CITY OF ALBUQUERQUE

**Planning Department
Transportation Development Services Section**

Re: Certification Submittal for Final Building Certificate of Occupancy for
Office Warehouse, [L-20 / D064]
601 General Hodges SE
Architect's Stamp Dated 01/07/09

**RE: 'OFFICE WAREHOUSE' LOCATED AT 601 GENERAL
HODGES S. E., ALBUQUERQUE, N. M.**

SITE PLAN 1" = 10'

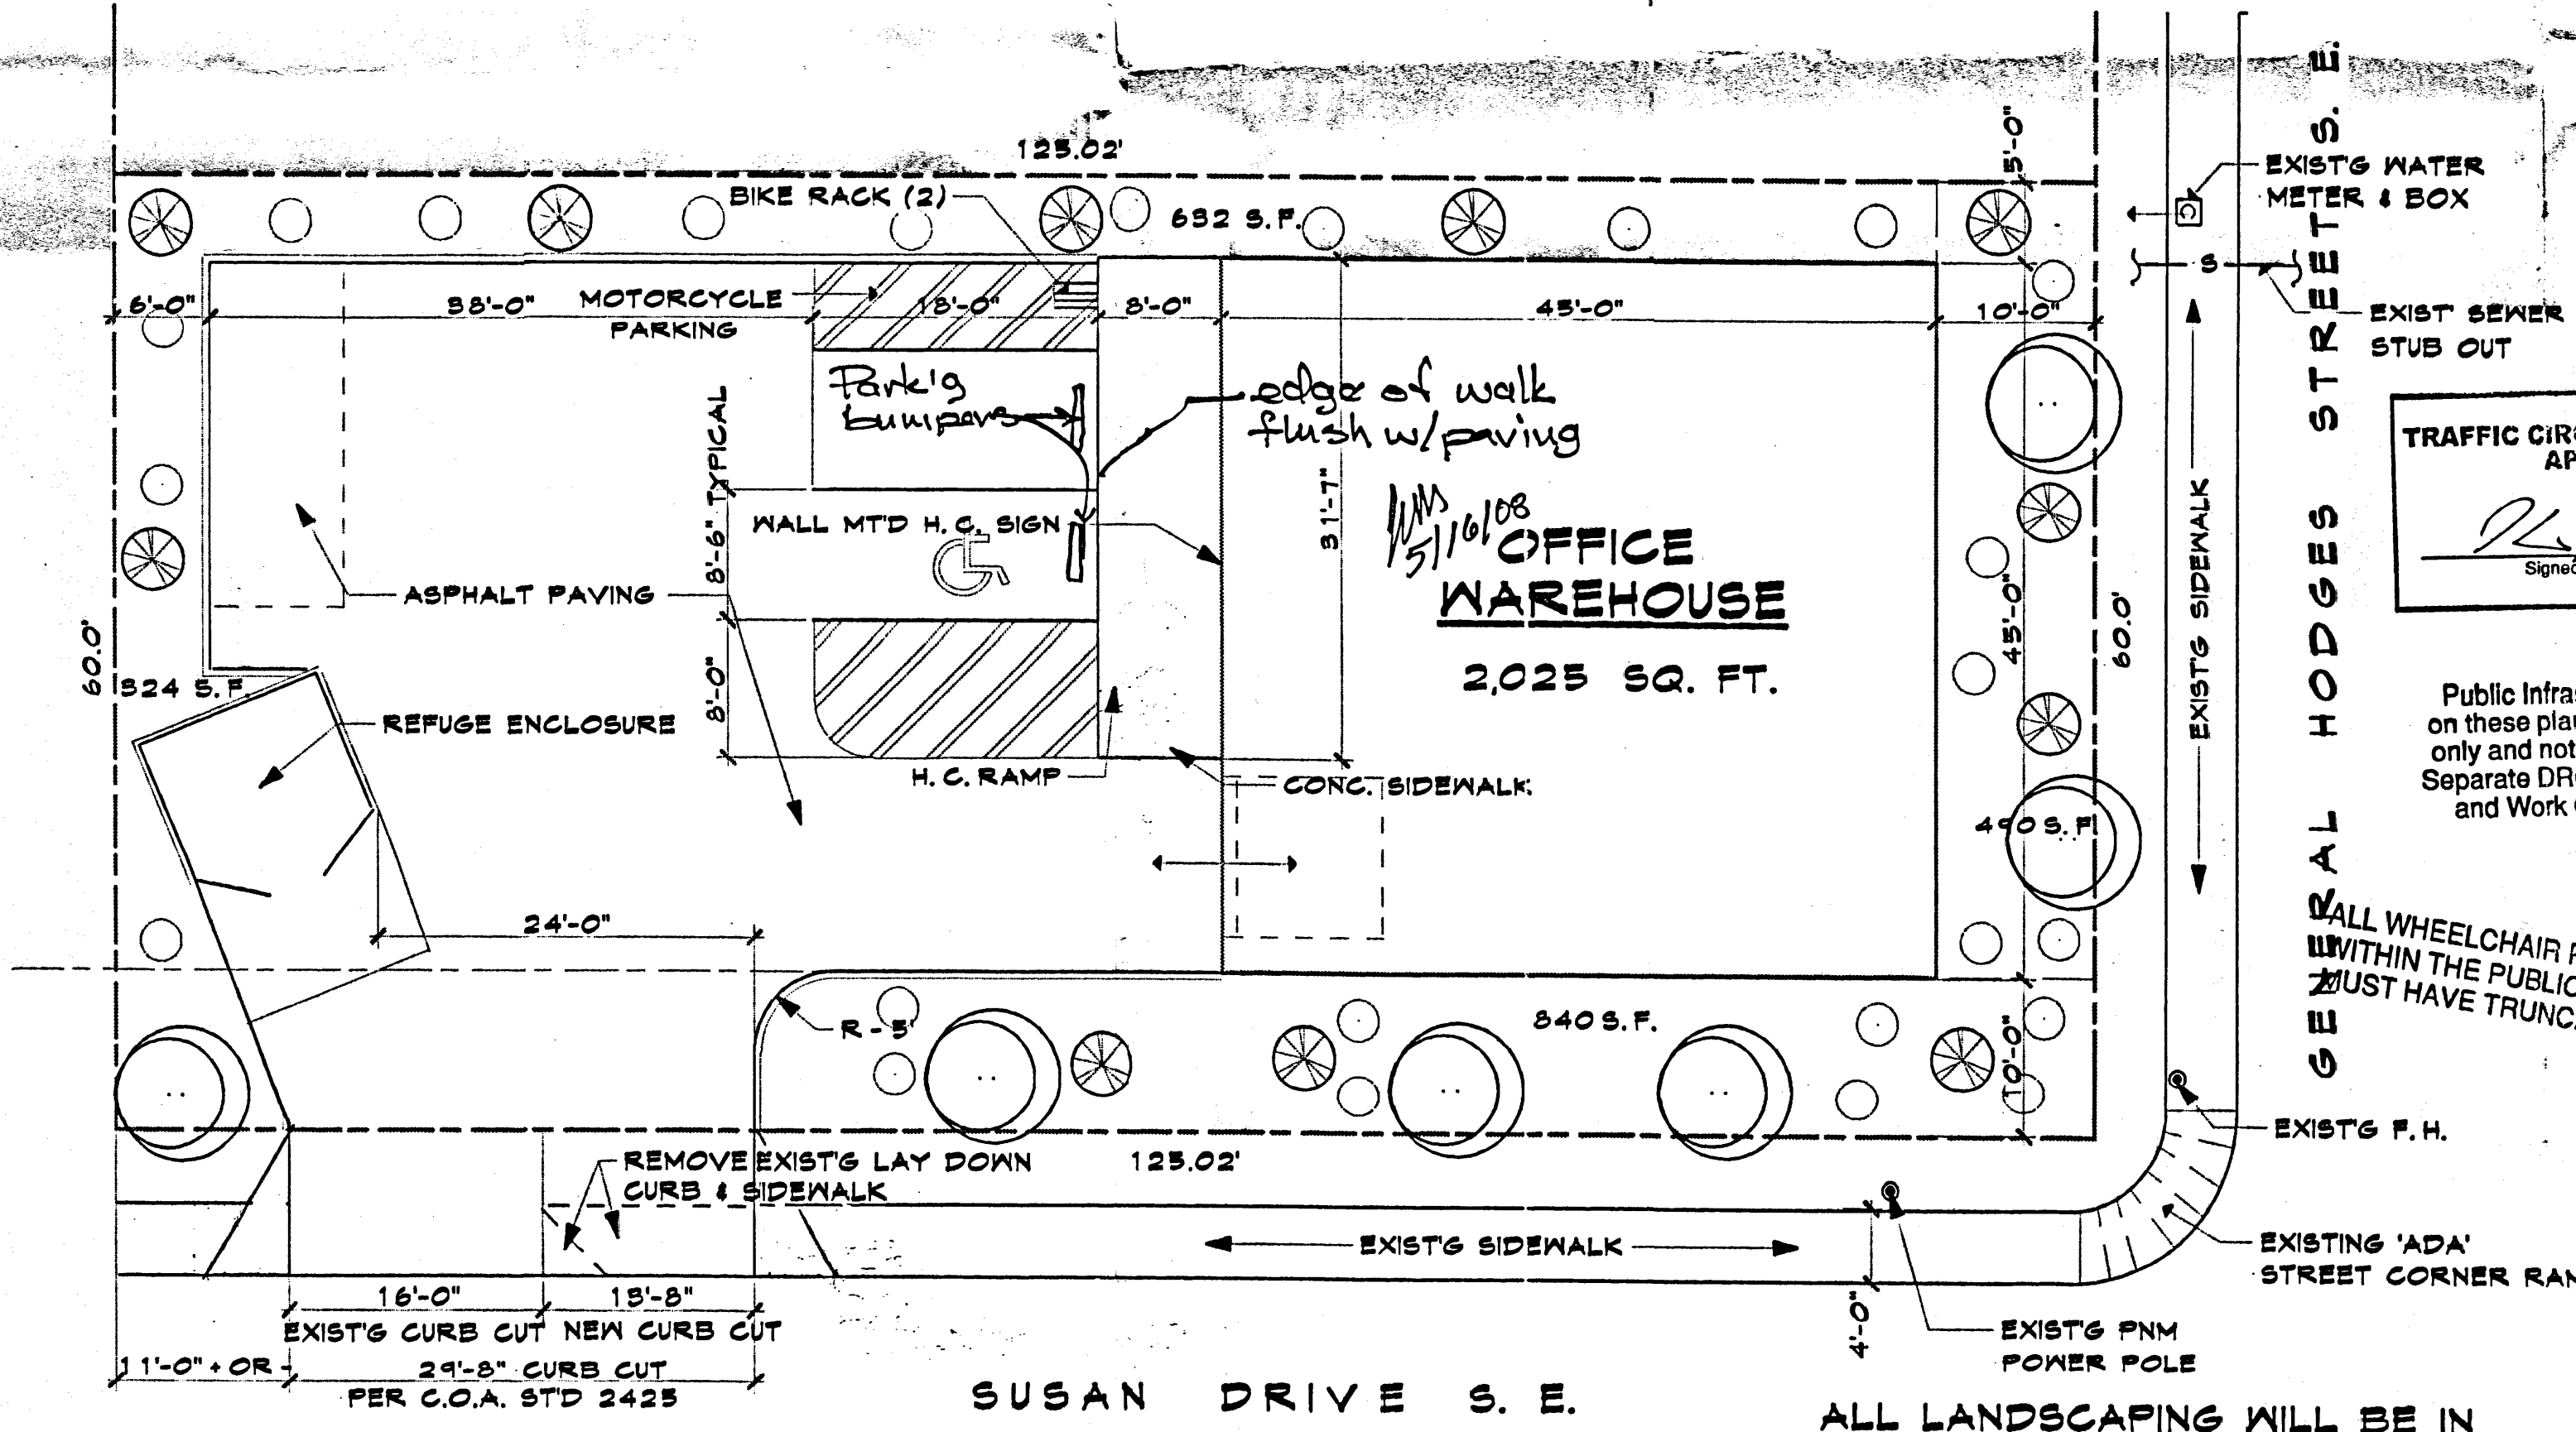
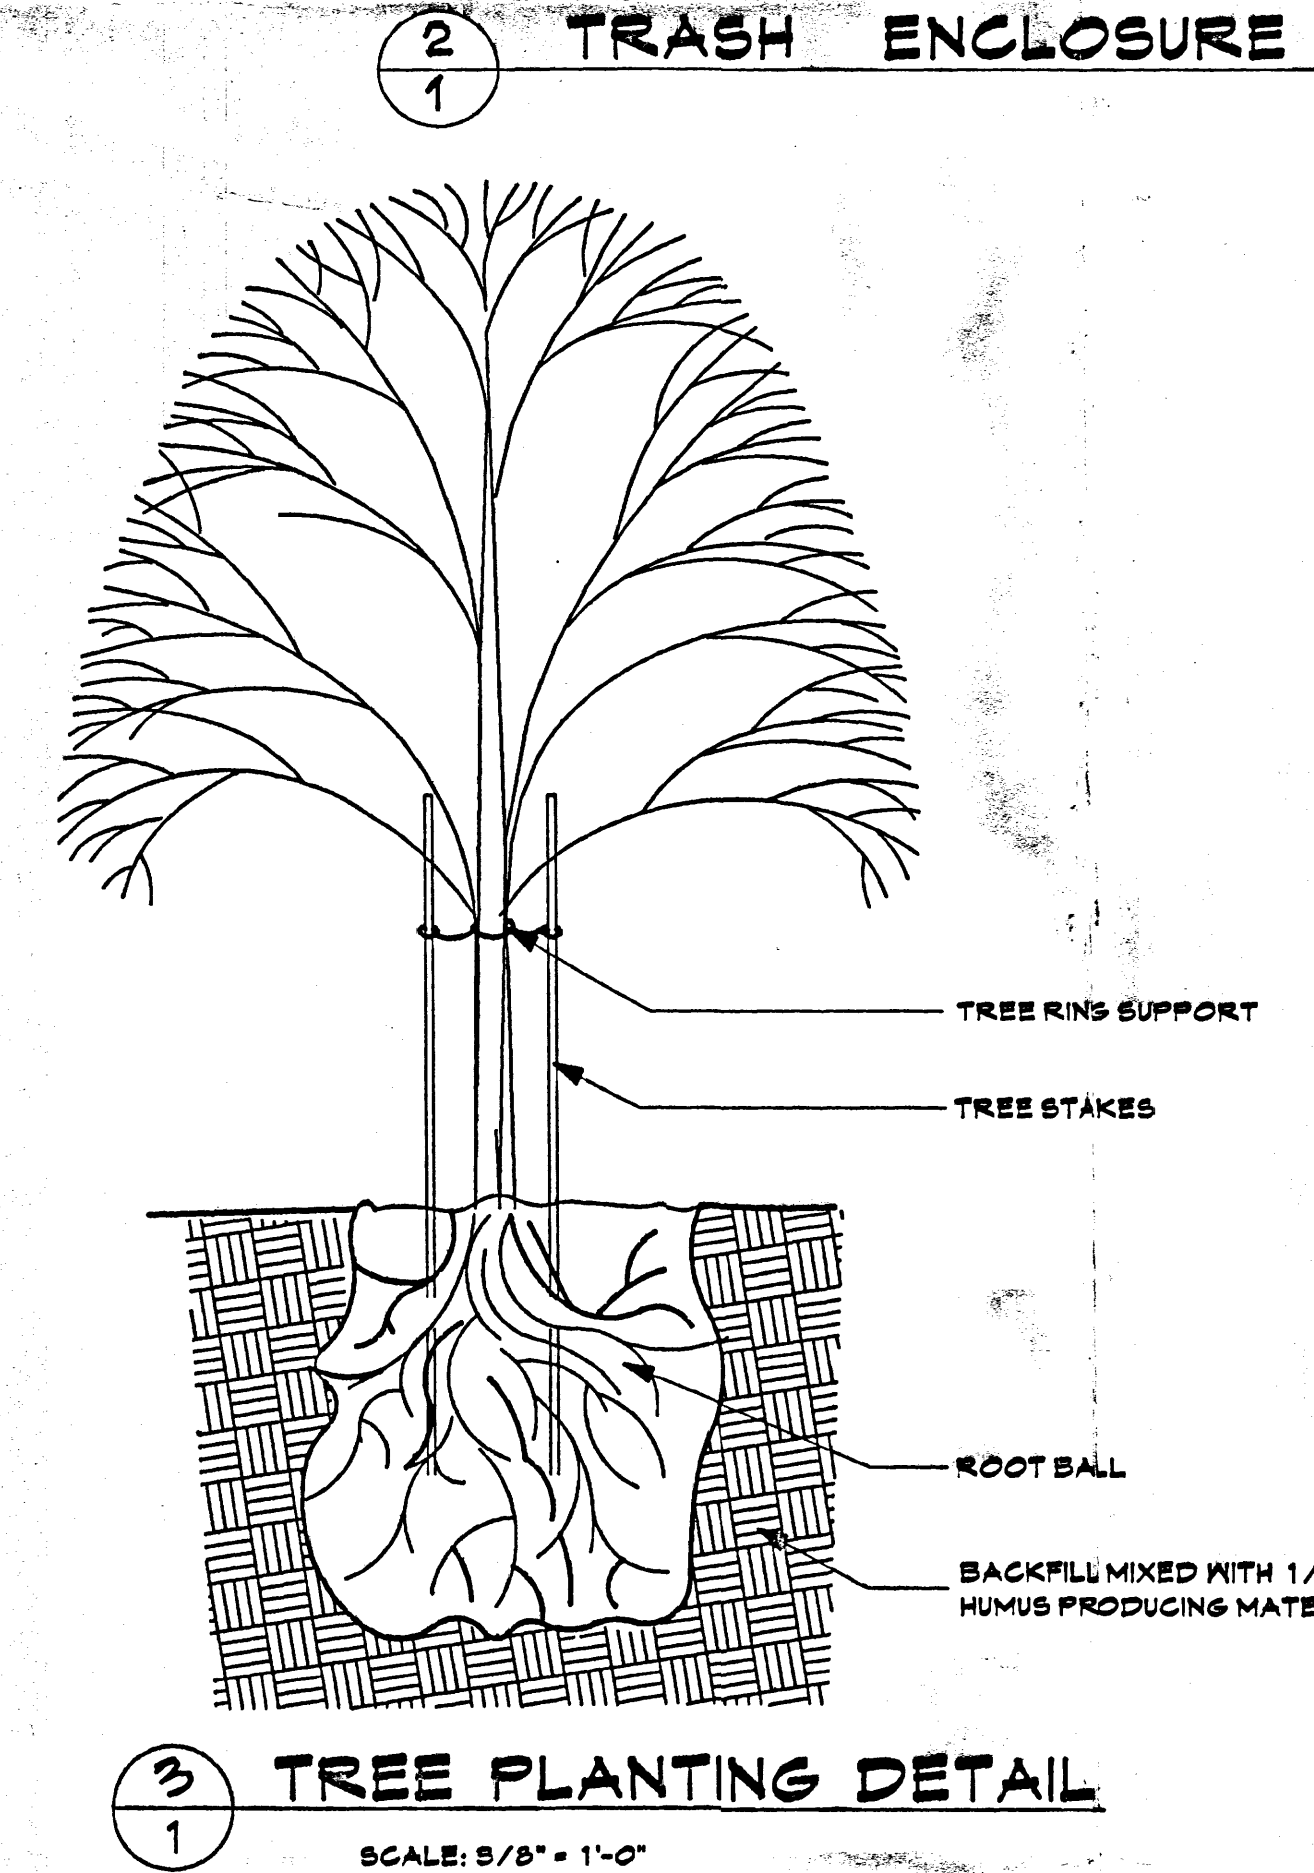
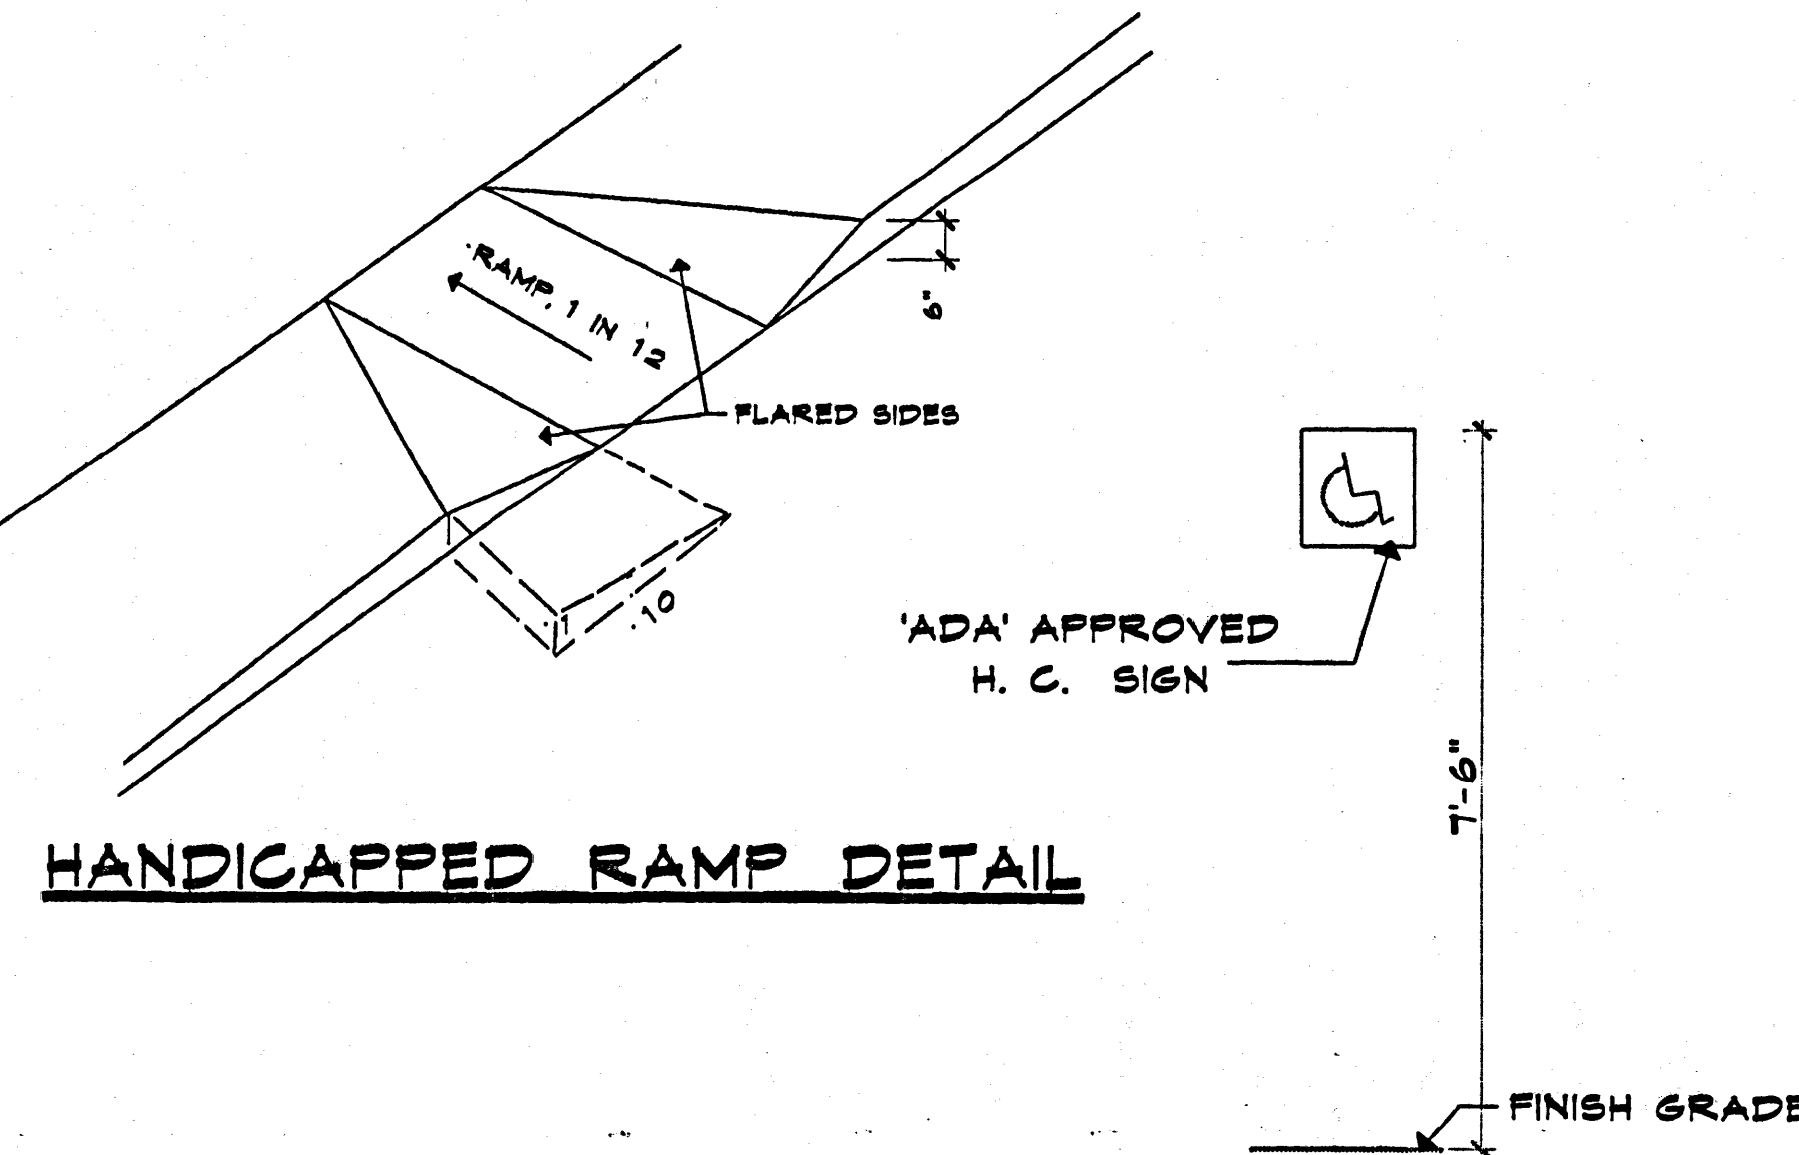
1. Call out the distance between the ramp and the edge of sidewalk to the east
of the handicapped ramp. This distance should be a minimum of 3', or
consider a different type of ramp.
2. CoA Standard 2425 does not have wheelchair ramps. Please amend your
plan accordingly.
3. Please stamp, sign, and date the plans.
